Our reference: ECM 9528324
Contact: Gavin Cherry
Telephone: (02) 4732 8125

14 April 2021

Response to Submissions – SSD-10479 – 200 Aldington Road Industrial Estate, Lots 54-58 DP 259135, 788-882 Mamre Road, Kemps Creek

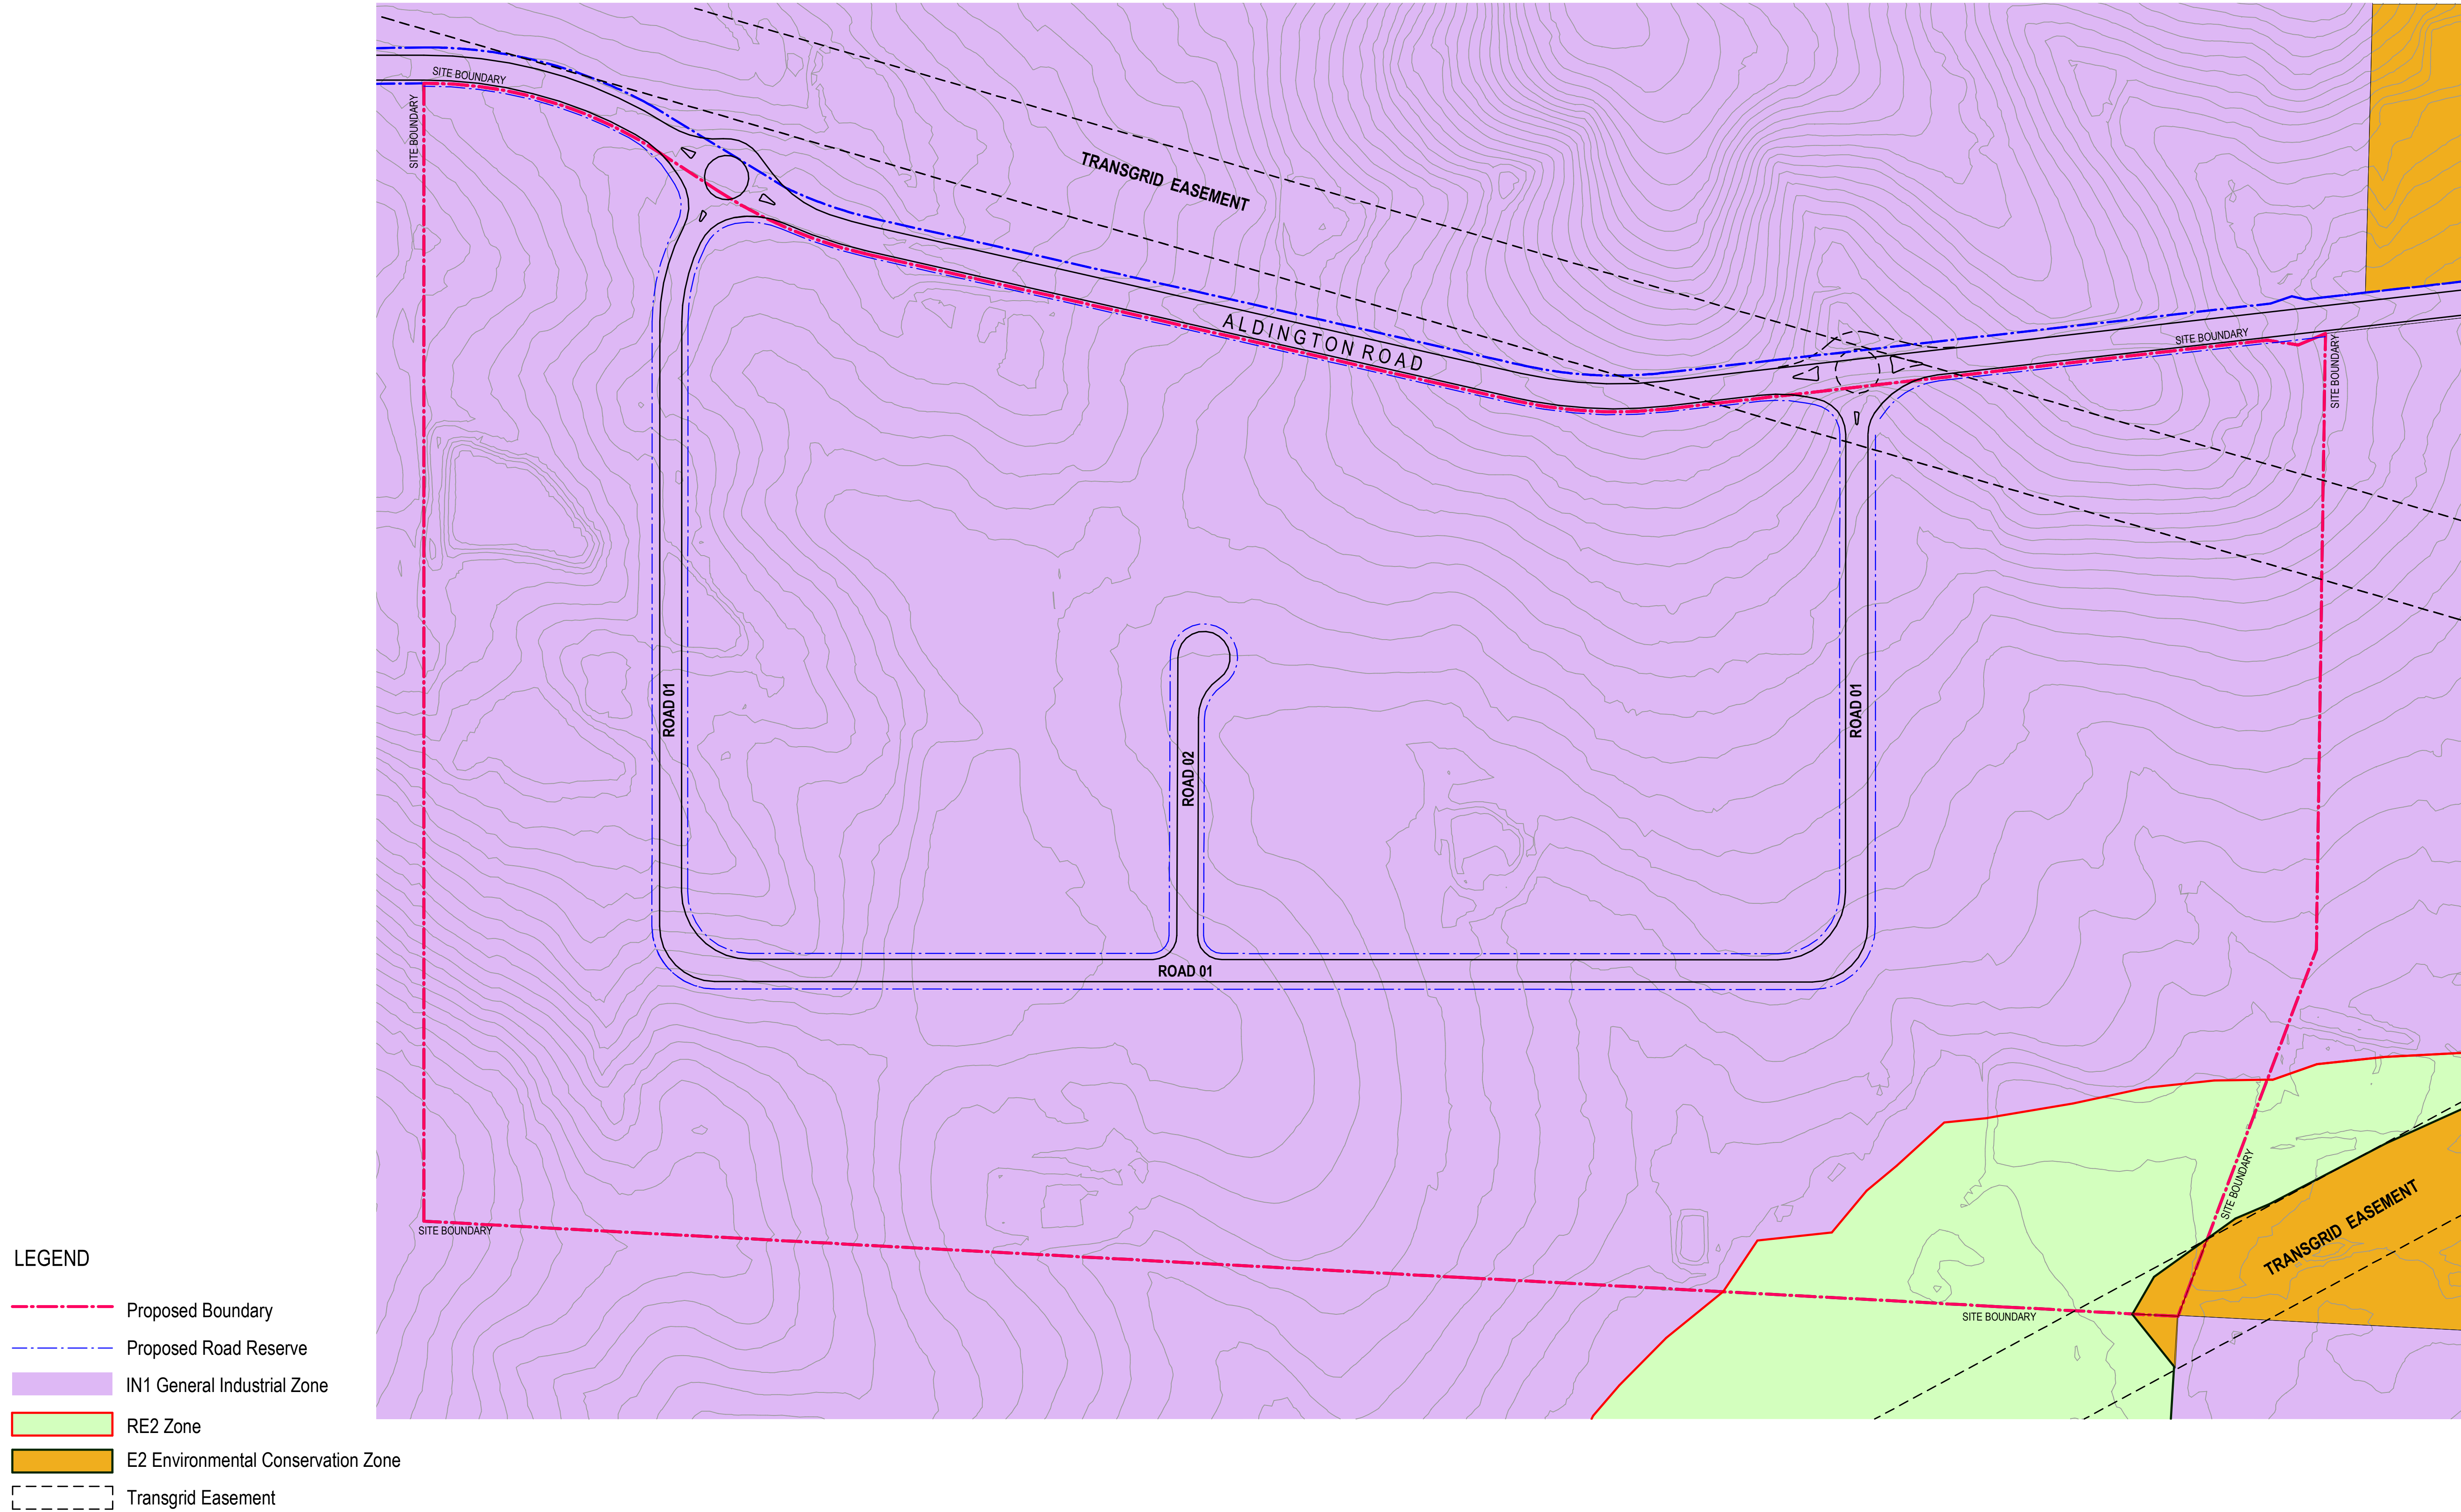
- The plans submitted as additional information provide no depictions of the actual setback dimensions. References to “landscape setback” or “building setback” do not allow for assessment on the adequacy of that setback noting that the setbacks vary between each and every proposed allotment. The EIS landscape plans and landscape cross sections provide varying landscape setbacks of between 3.75m - 8.4m to the internal road network as proposed. Of particular concern is in the inadequacy of indicated setbacks to address the level difference between the verge level and the finished ground levels for truck manoeuvring as per Section F-F.

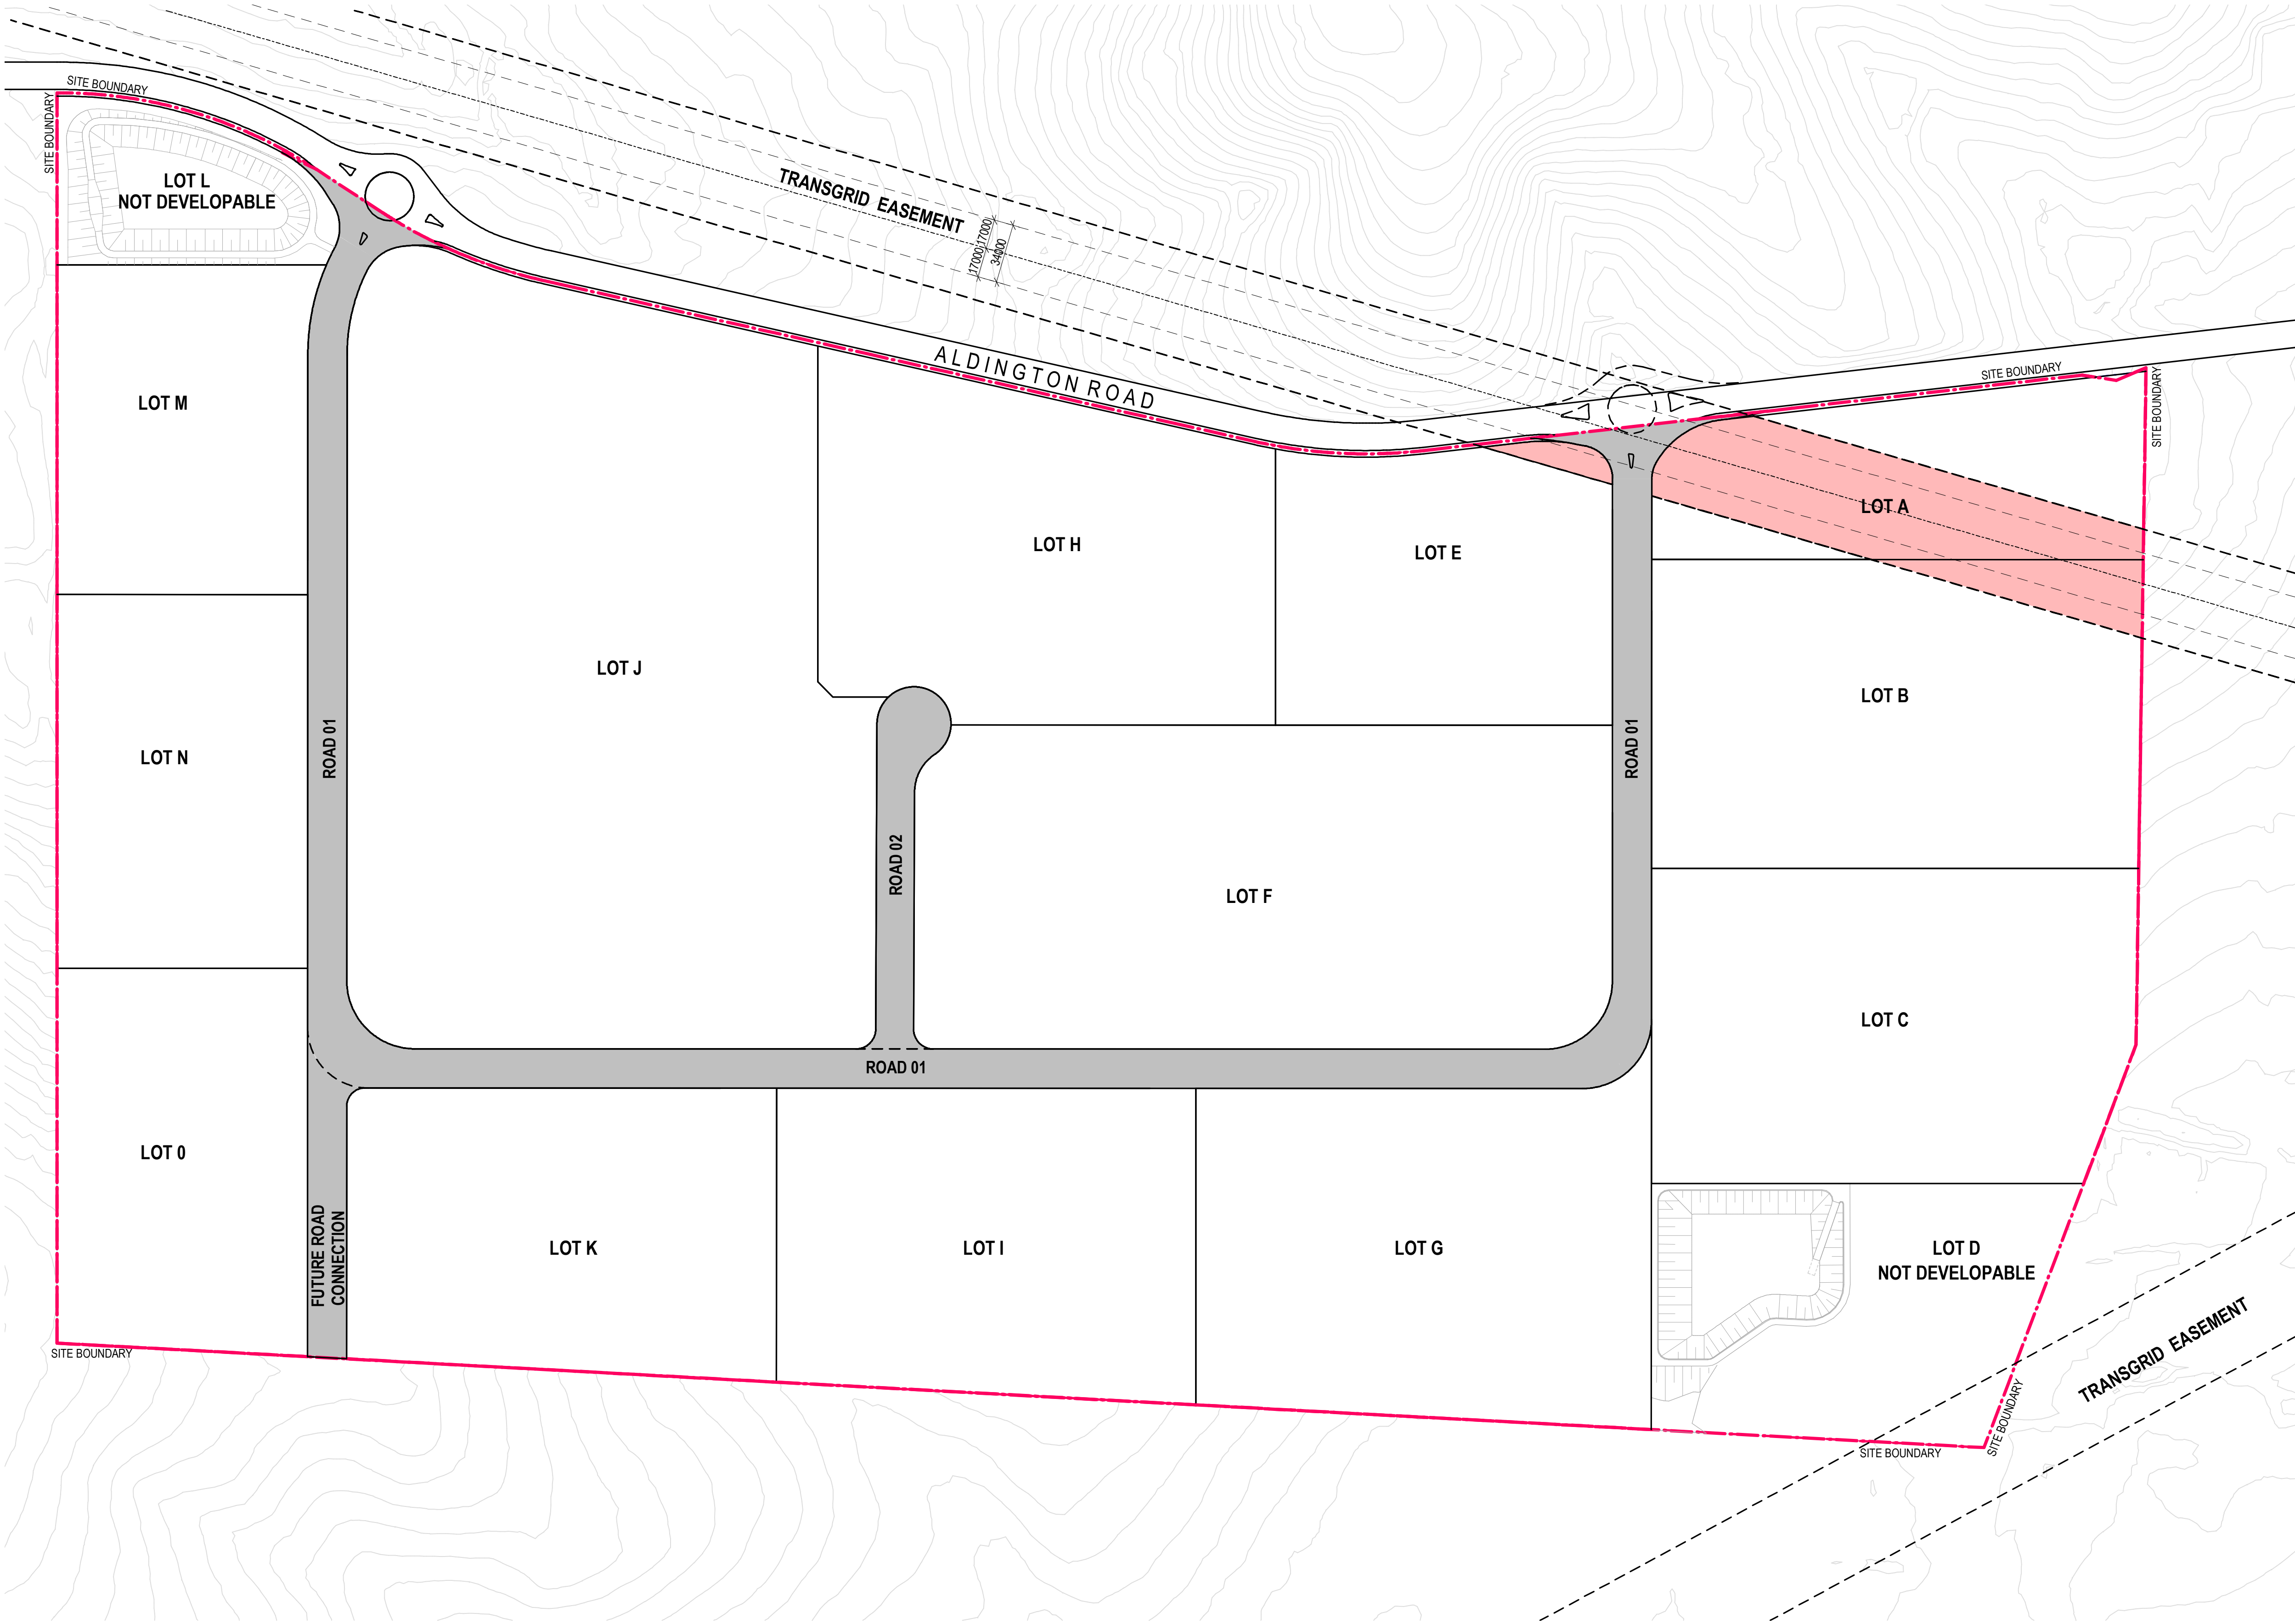
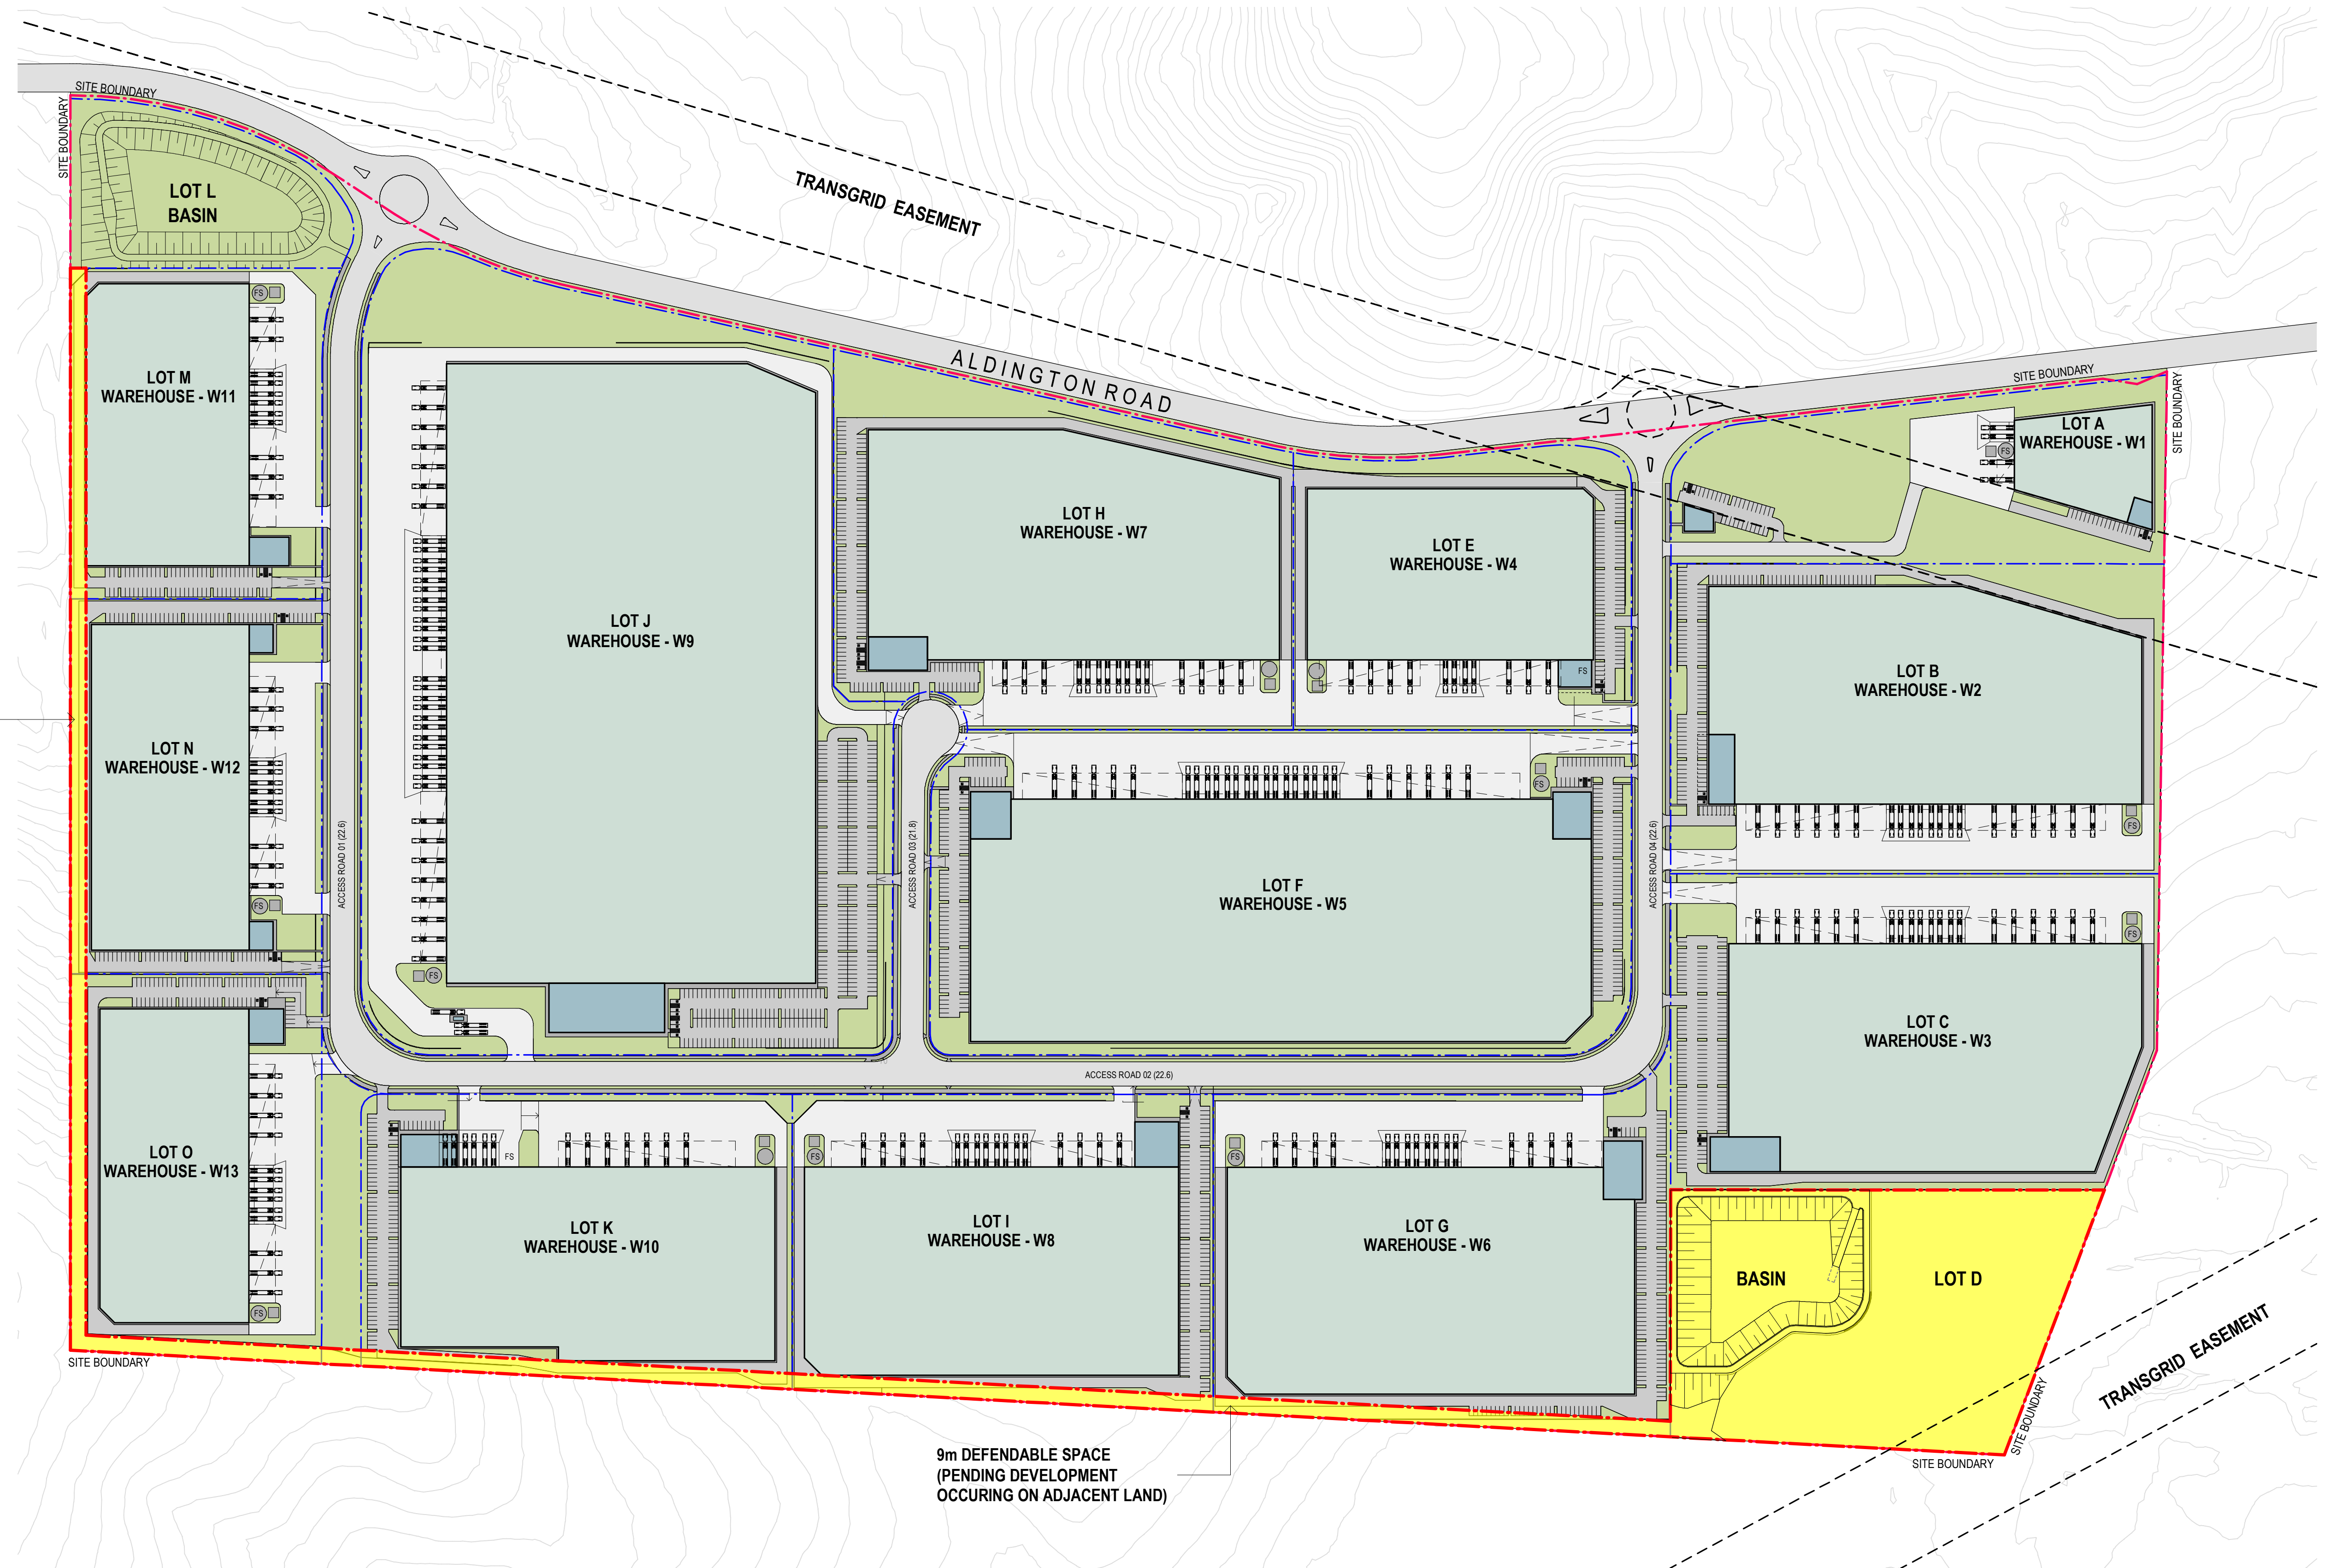
- Council reiterates that the proposed height of the estate pylon signs as originally lodged is excessive, and these should be reduced in height or deleted altogether as an unnecessary signage feature. At the very least, only one estate pylon sign should be provided to each intersection with Aldington Road. A variation to the draft DCP is unwarranted and unreasonable and the cumulation and visual impact of the proposed signage structures requires reconsideration, especially any suggestion for a signage width of 3m which is excessive and an unsympathetic element within the streetscape.
